Our ref: NO/2020/112925/03-L01
Your ref: 3/2020/0602
Date: 03 September 2021

**CREATION OF ADDITIONAL DINING SPACE, A BAKERY DELI FOOD SALES AREA WITH STORAGE AND OFFICE FACILITIES. ADDITIONAL TERRACE DINING WITH STORAGE BELOW.
HOLDEN CLOUGH NURSERY, BOLTON BY BOWLAND ROAD, BOLTON BY BOWLAND, BB7 4PF**

Mr N Stones		
Proposed Alterations Hargreaves Woone Lane Clitheroe		
Existing Side Elevation		
Scale 1:50	Date 10.06.21	Drawn by PD
Drawings 1238 - 08	Rev -

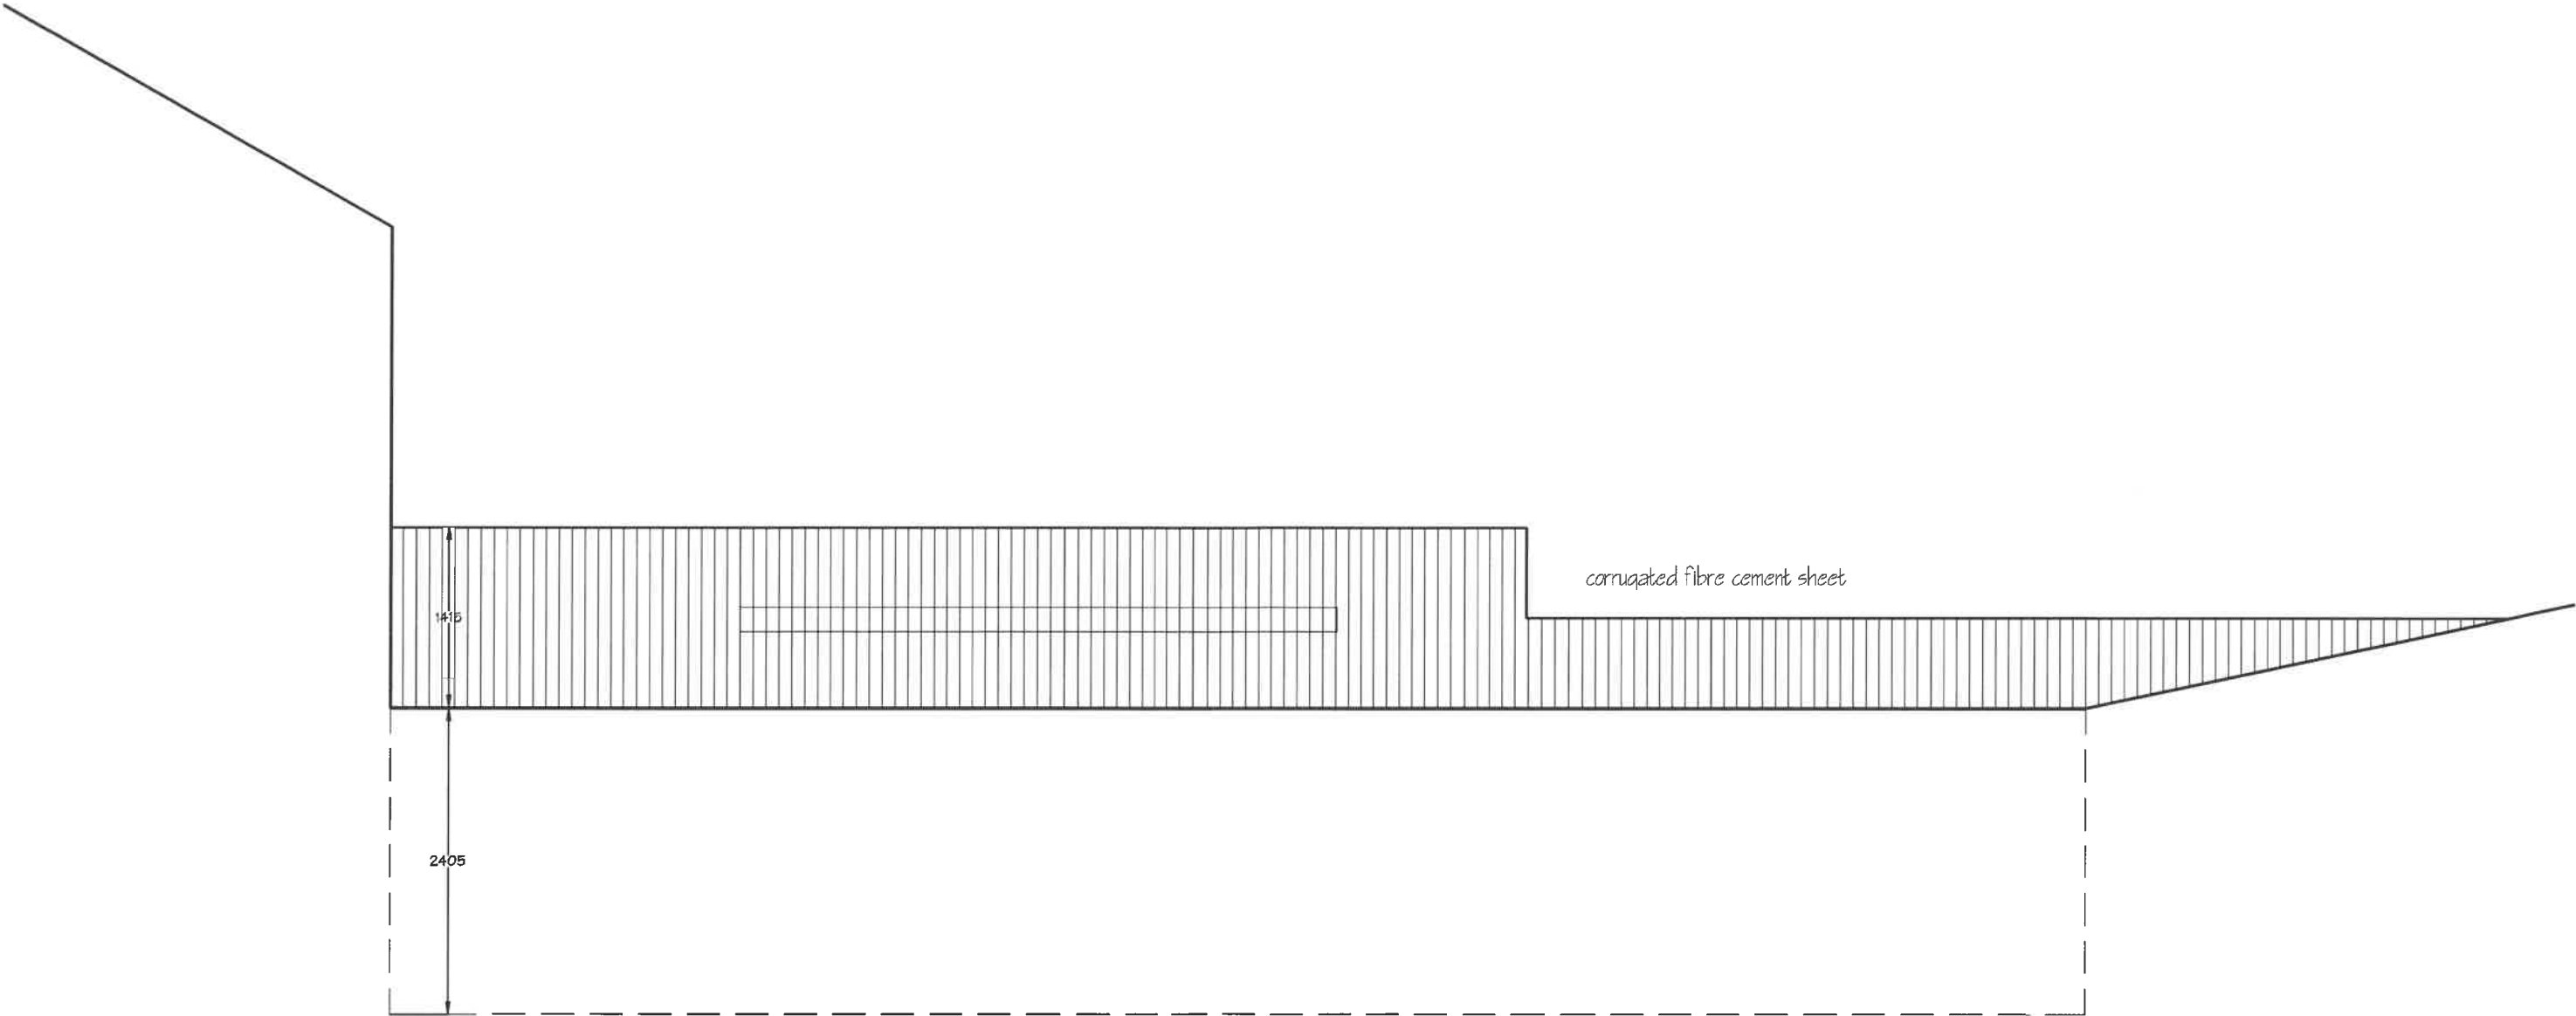
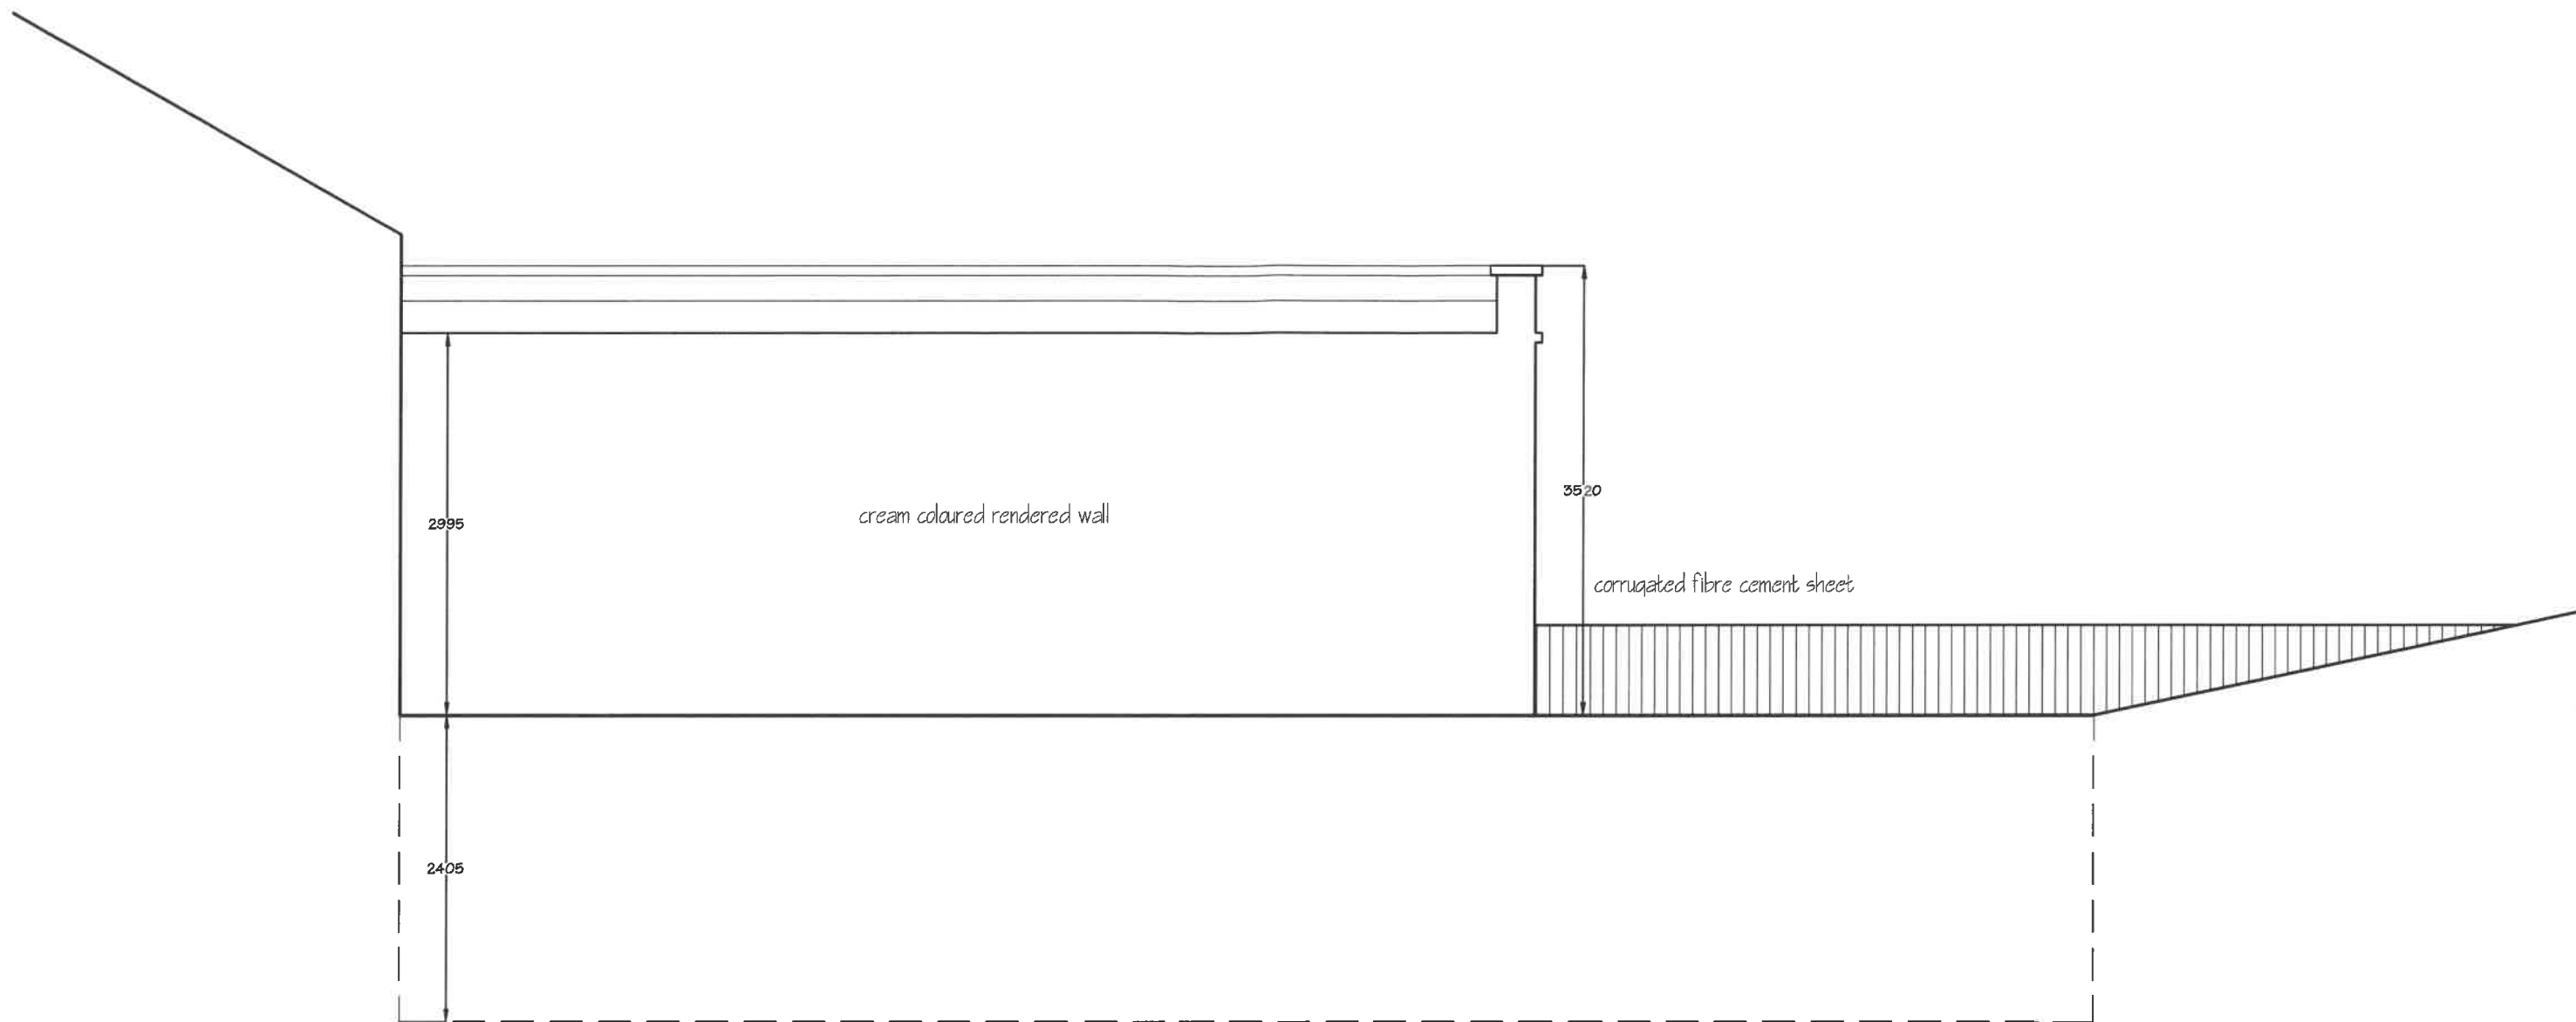
The proposed and existing elevations submitted with this application show that there are likely to be ground level alterations within the 1% AEP plus climate change extent. The impact of ground level raising within the flood plain is likely to result in loss of flood plain storage and/or impeding of flows is likely to increase flood risk elsewhere. This would be contrary to Paragraph 155 of the NPPF.

Whilst not mentioned within the FRA, the proposed and existing elevations show discrepancies between existing and proposed ground levels, the impact of this has not been confirmed or assessed. The applicant should confirm whether ground levels will be raised, and if this is the case, this must be assessed within the FRA, including the extent and impact of any loss of flood plain storage. If this is proposed, compensatory storage must be provided on a level-for-level basis for the 1% AEP plus allowance for climate change extent.
